Gatwick Northern Runway Development Consent Order Application TR020005

Reigate & Banstead Borough Council

Relevant Representation

26 October 2023

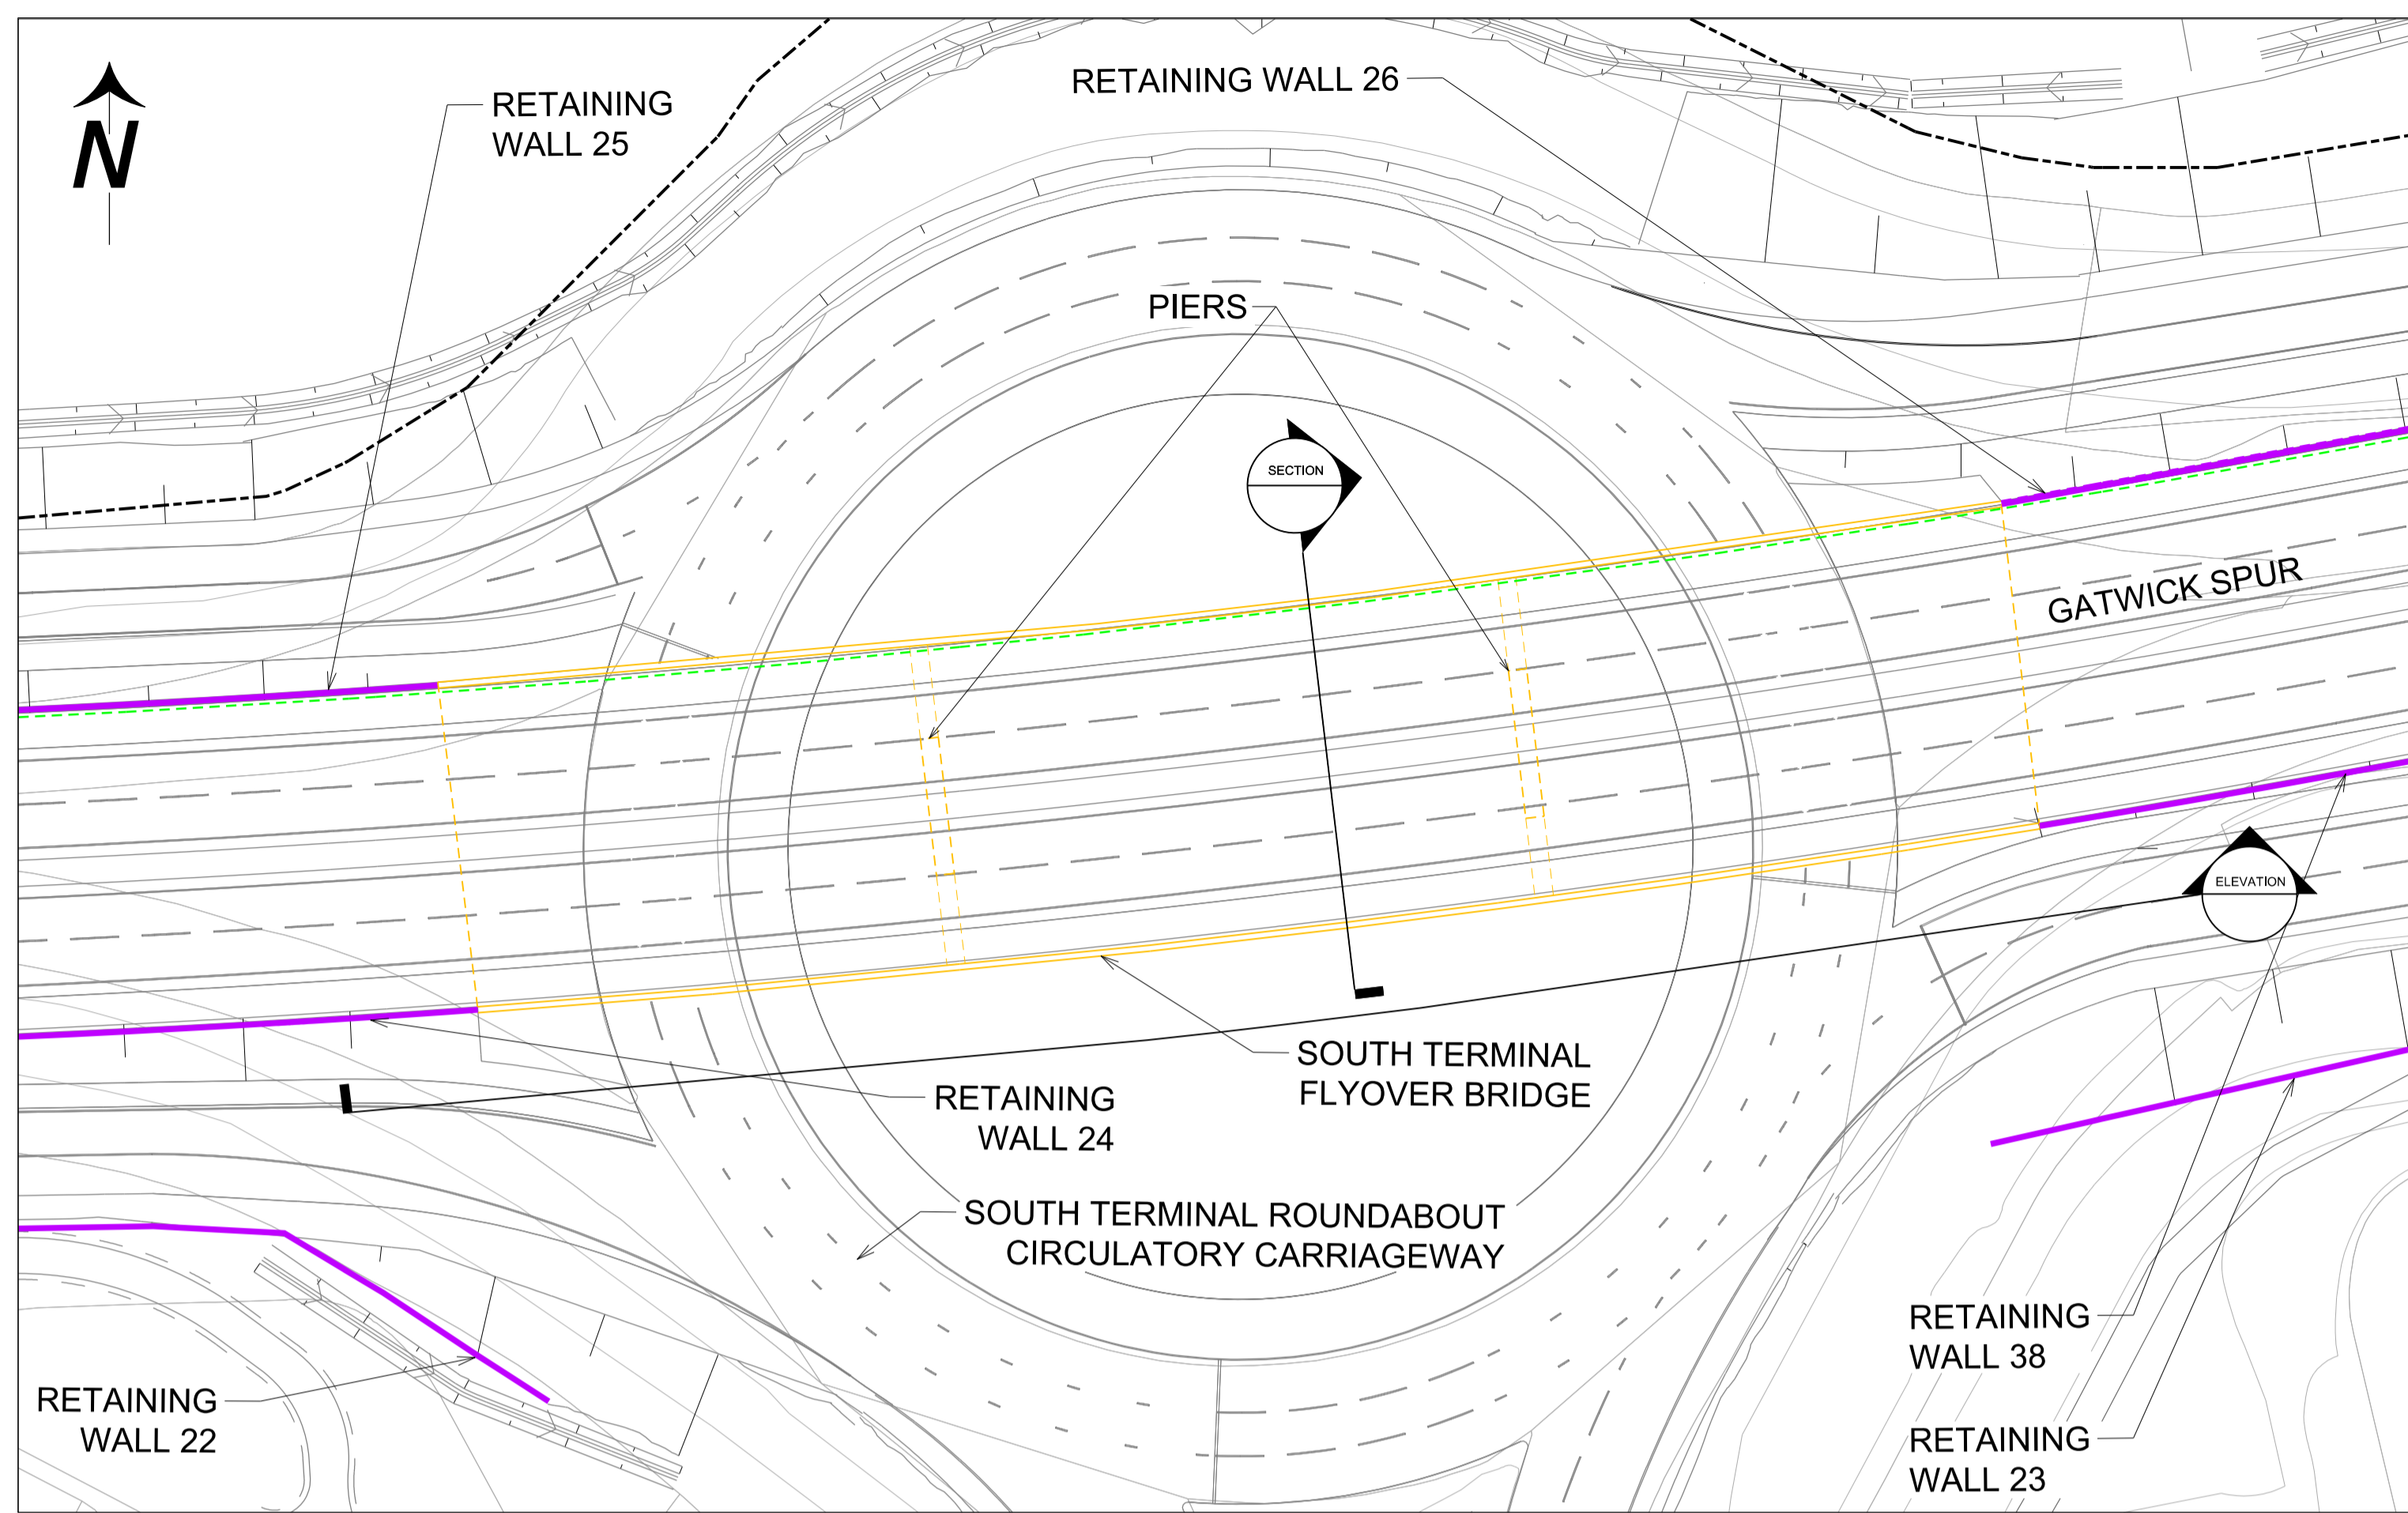
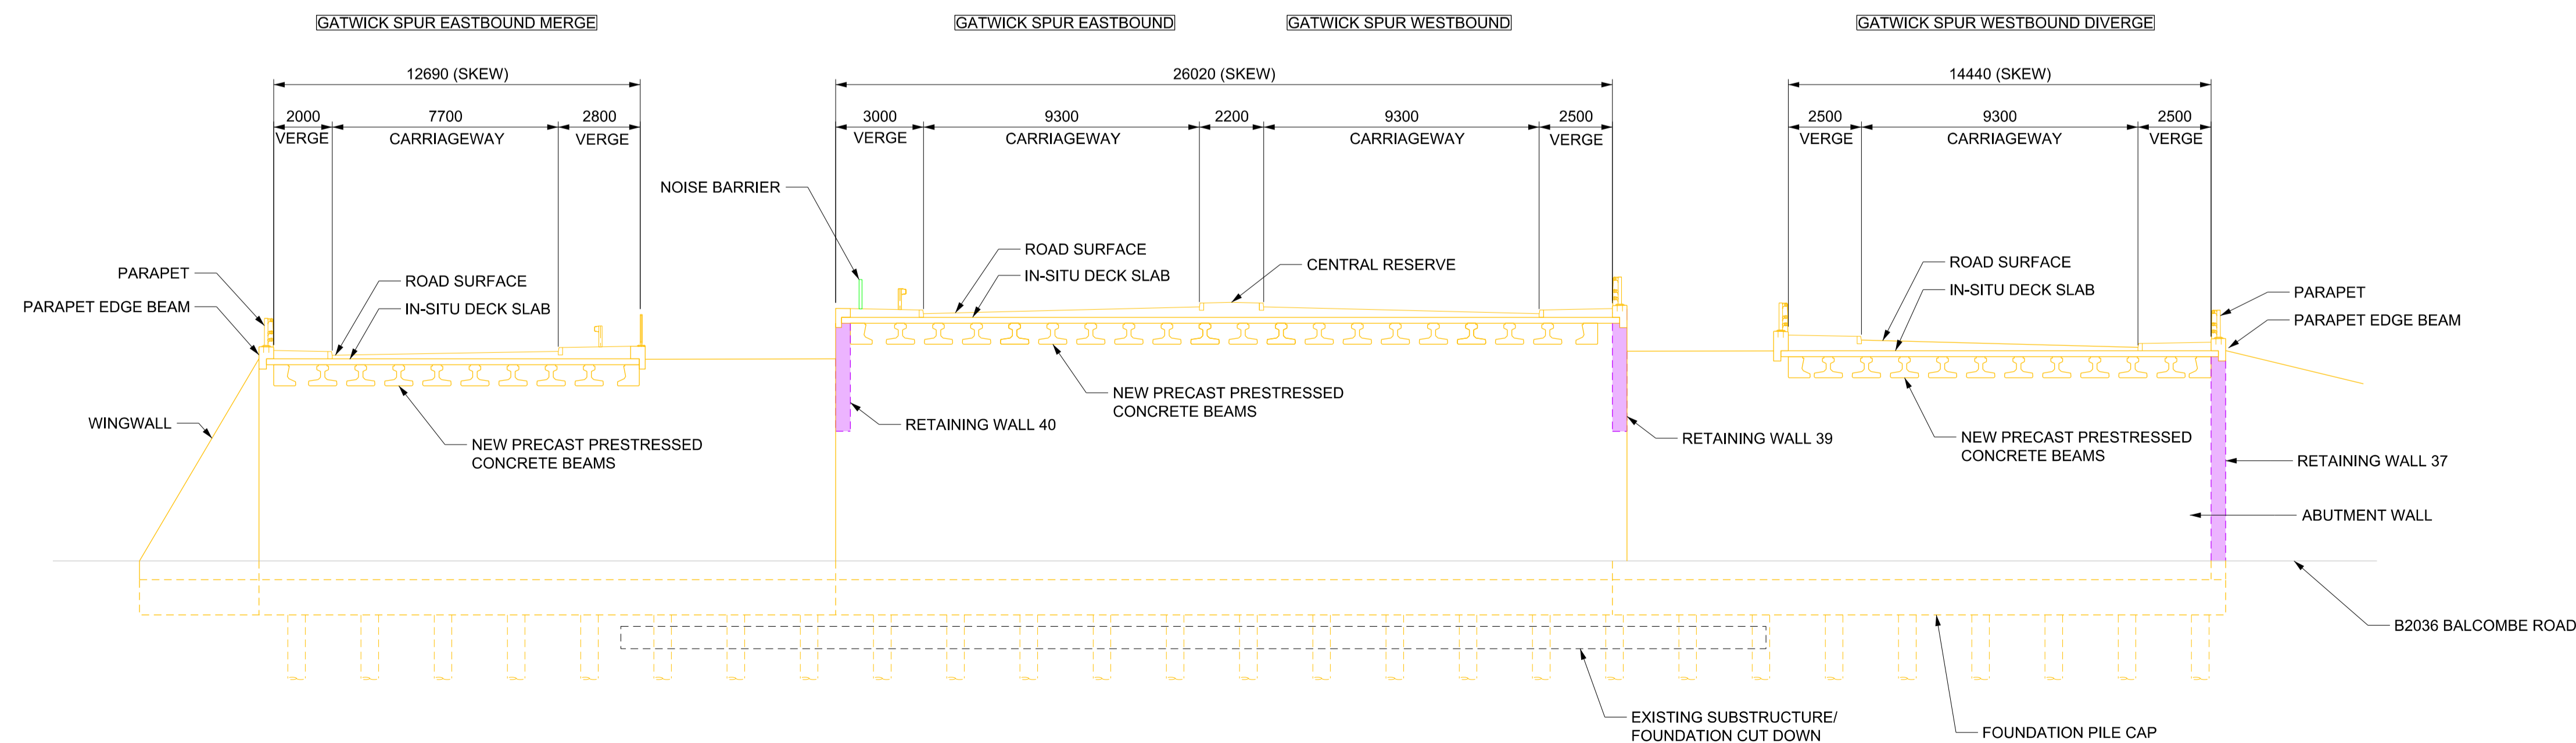
11. A major impact will be the increased width of the new A23 London Road bridge of about 22 metres and associated road widening, including the introduction of segregated footpaths and cycle tracks on both sides of the road, part of which will cut into the historic Church Meadows. The width of the bridge combined with a loss of grass verges on the Reigate side will be a move away from the vestiges of a more rural appearance. We are unclear if alternative options were considered regarding the impact of a wider bridge over the A23 London Road.
